# KITITITAS COUNTY

### MEMORANDUM

TO: All Staff  
FROM: Justin Turnbull, County Surveyor   
DATE: May 20, 2021  
SUBJECT: County 2<sup>nd</sup> Survey Review of Final Cluster Plat LPF-20-00005 (Forest Ridge Ph1)

FOREST RIDGE - PHASE I PERFORMANCE BASED CLUSTER PLAT PREPARED FOR FRPP PHASE I, LLC A PORTION OF SECTION 24, TOWNSHIP 20 NORTH, RANGE 15 EAST, W.M. KITITAS COUNTY WASHINGTON		
DWN BY T.S.	DATE 05/2021	JOB NO. 18069
CHKD BY M.K.K./D.L.P.	SCALE 1" = 100'	SHEET 4 OF 7

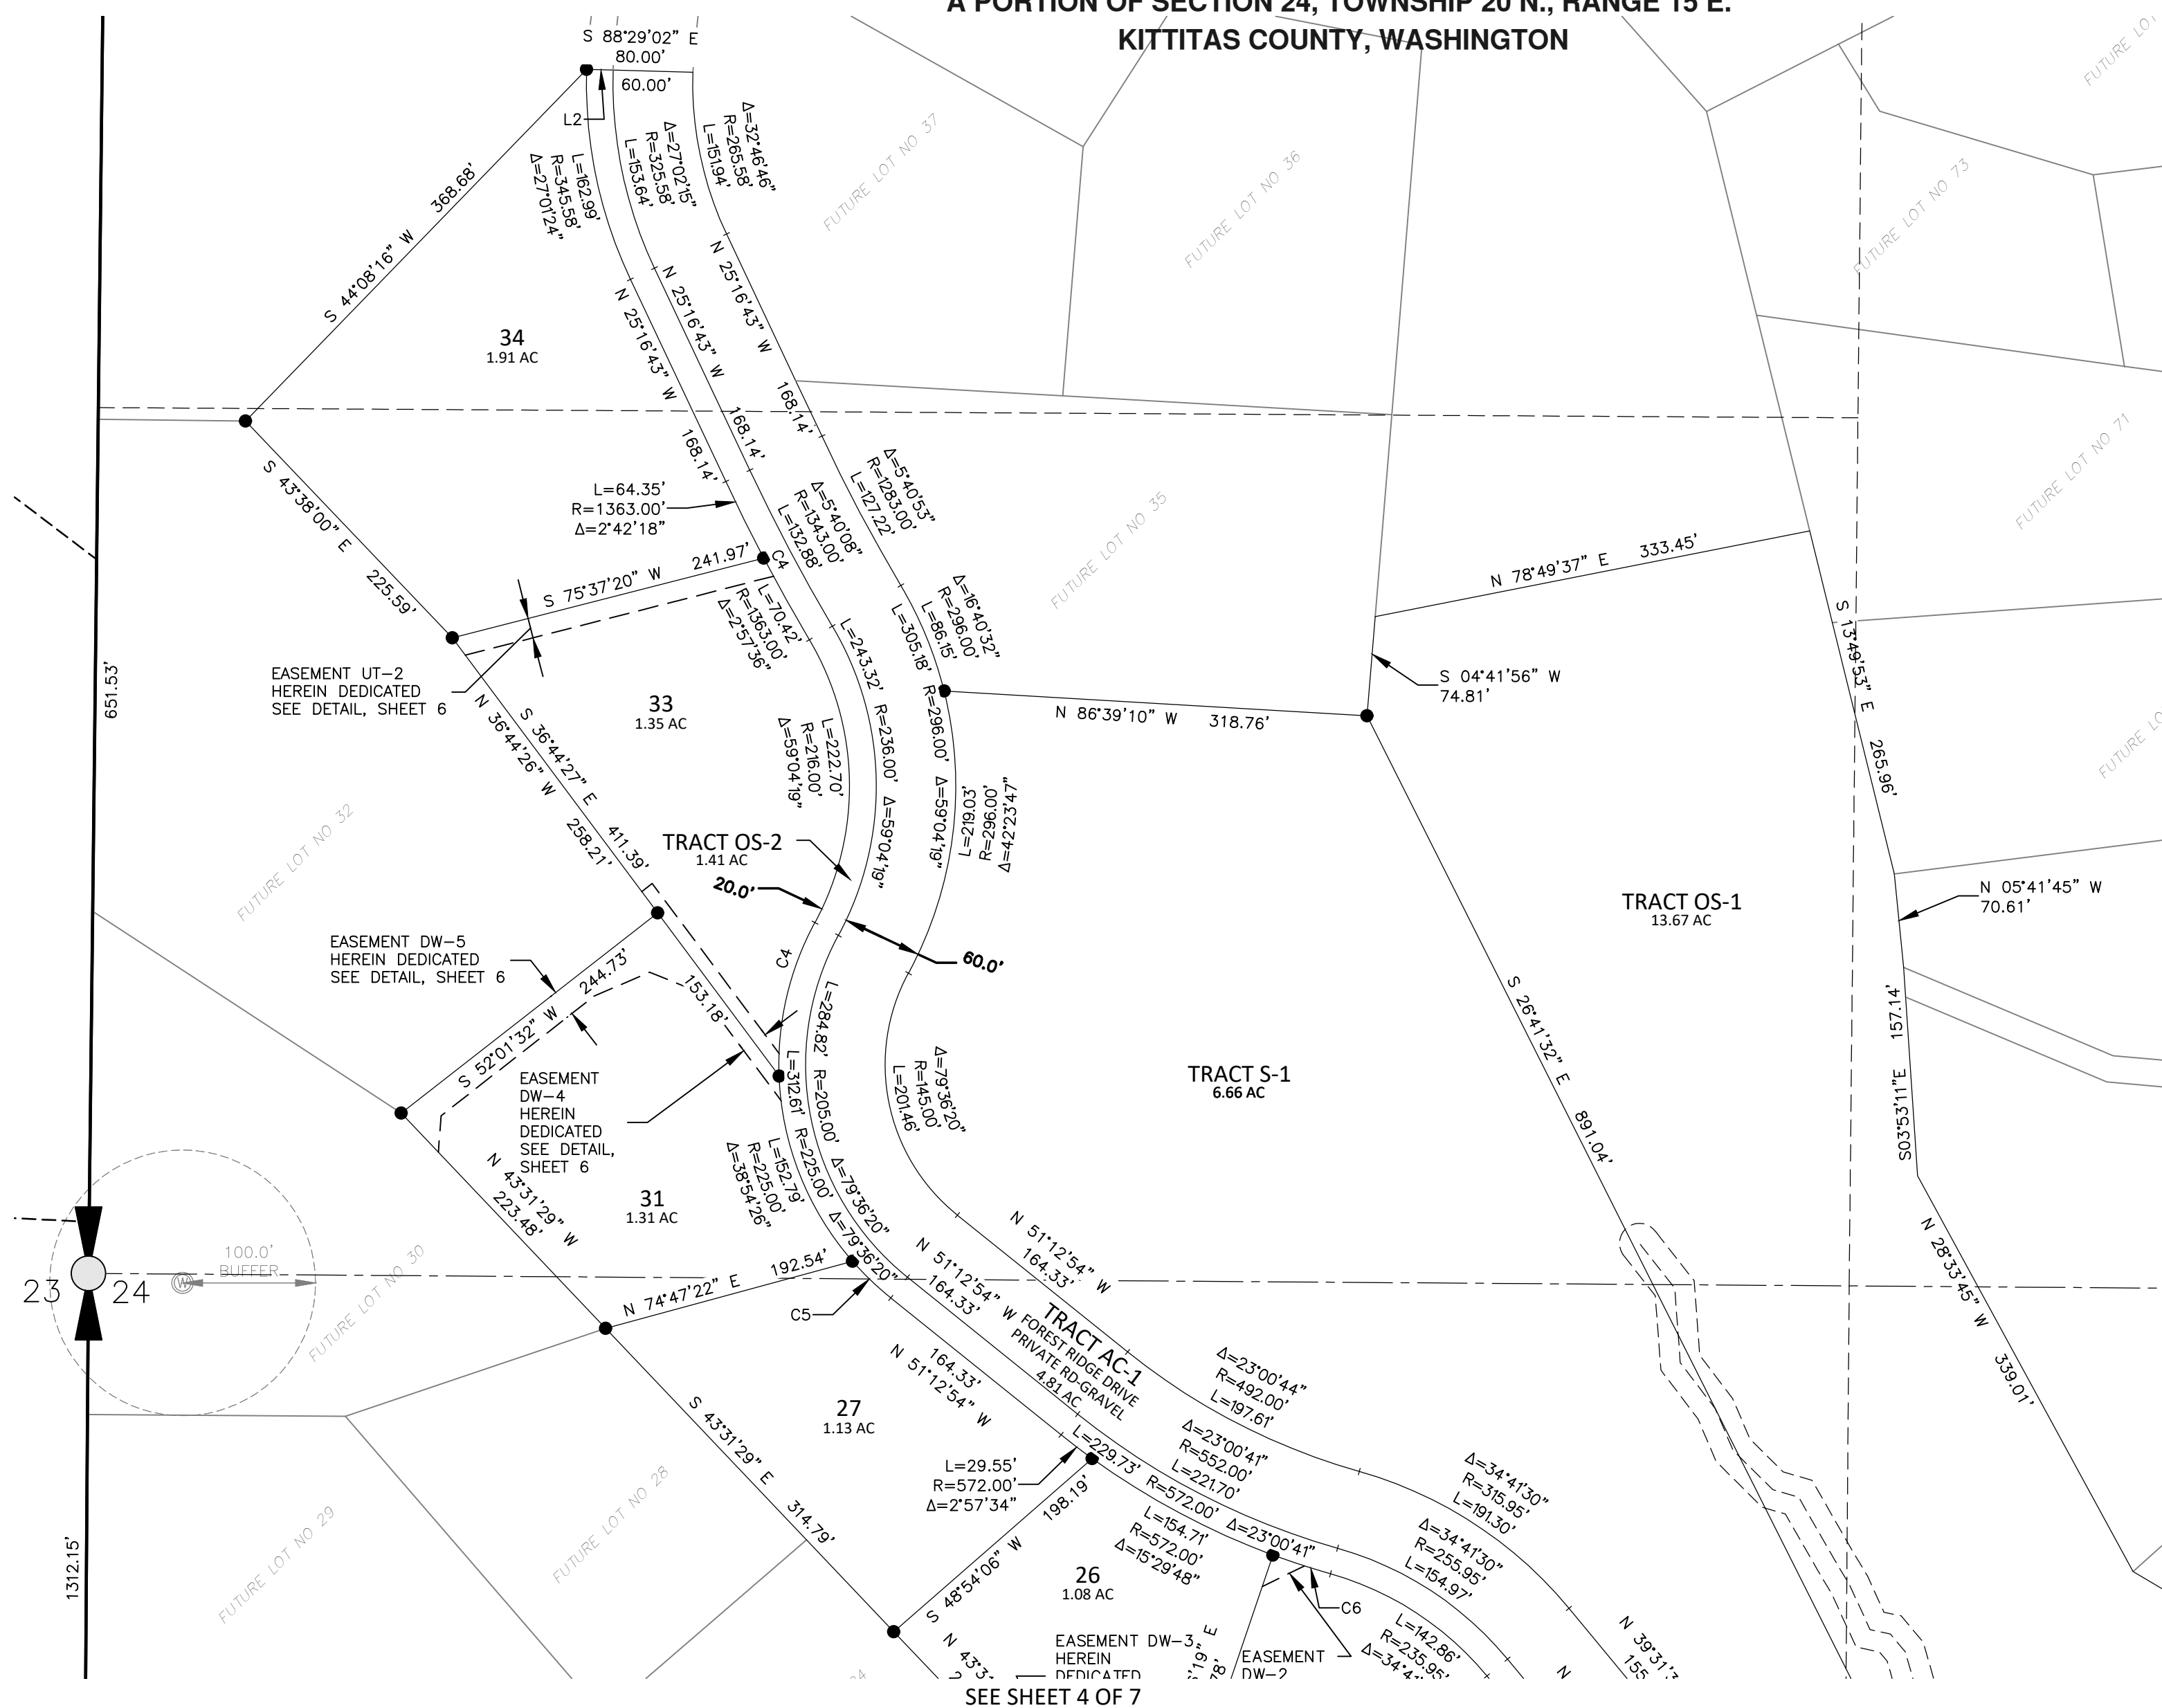
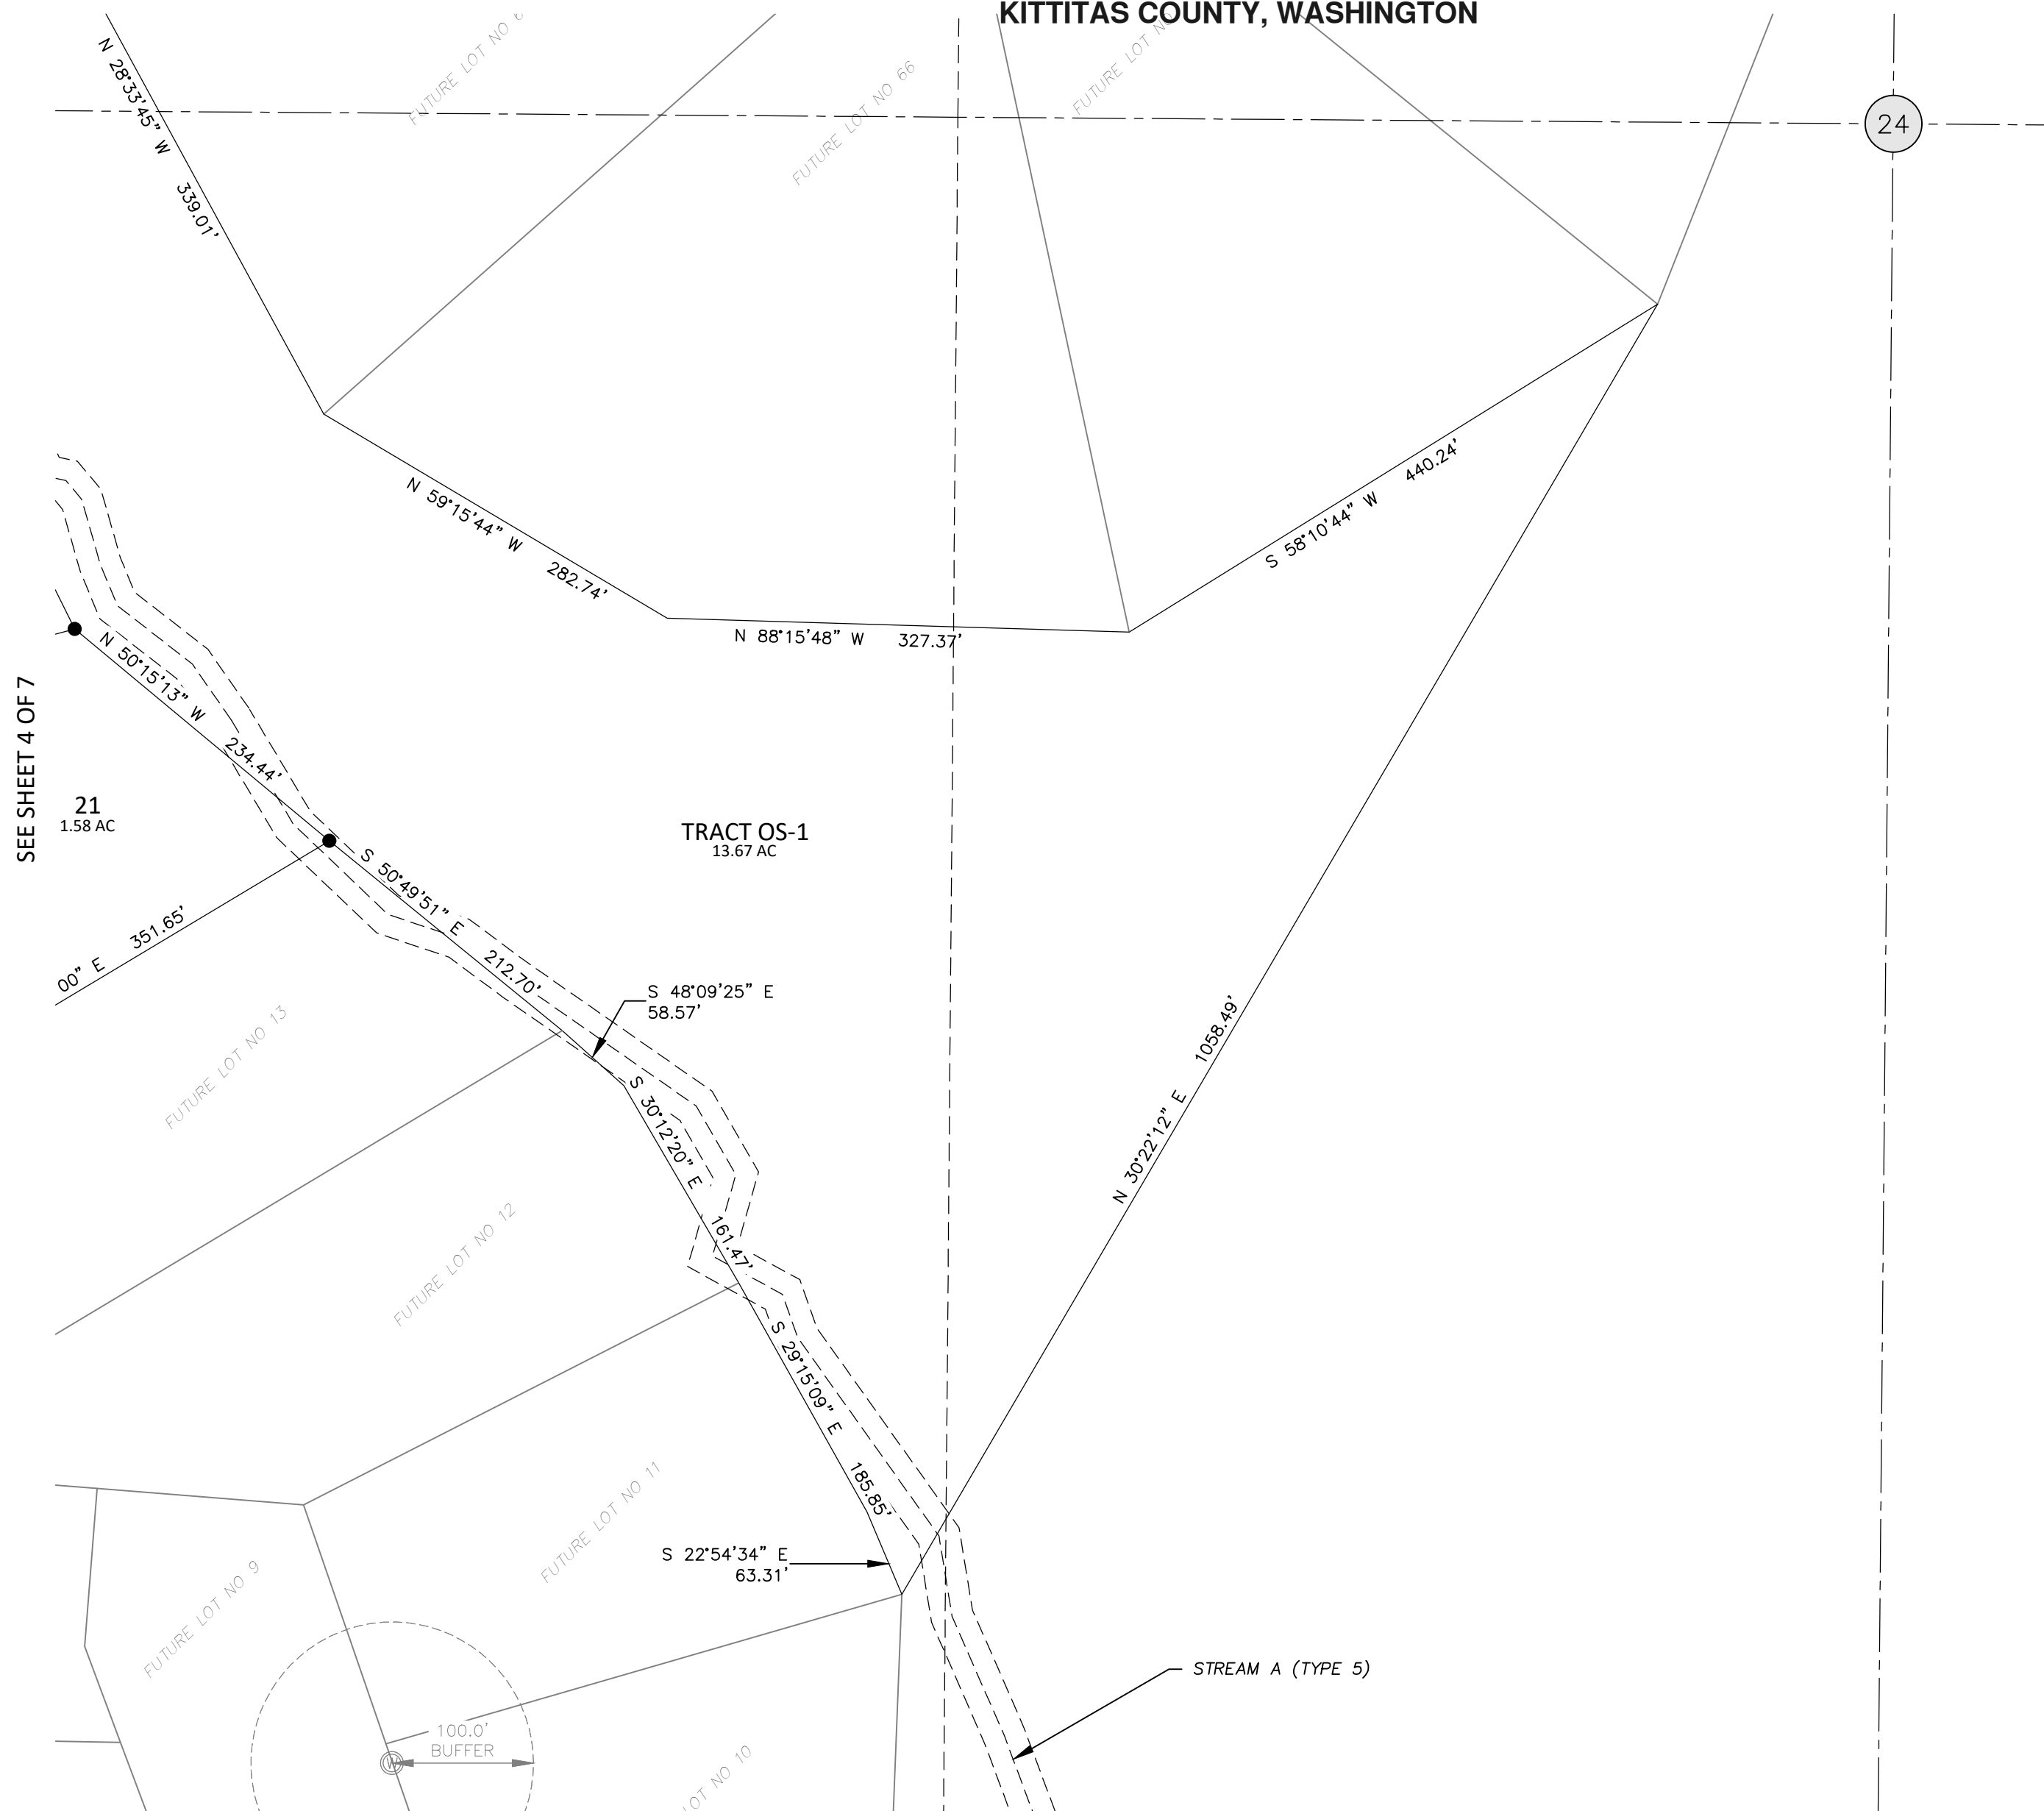
2. All the easements DW-1 through DW-5 and UT-1 through UT-2 incorrectly reference sheet 6 rather than Sheet 7.
3. The dimension of 421.23 at the south end of AC-1 should show 'crows feet' to identify what the dimension is measuring.
4. There are still multiple occurrences of crossing linework obscuring text.

5. The following Line/curve labels do not appear on a line or curve table:  
C2, C7, C14, L3, L4, and L5
6. C4 appears in 2 locations, the Northernmost one being incorrect and located near the N'most corner of lot 33. It should be removed.

7. The division between DW-4 and DW-5 should be identified.
8. The N'most curve in Lot 34 does not match the closure report. This particular curve is also mismatched between the closure report values for Lot 34 and OS-2.
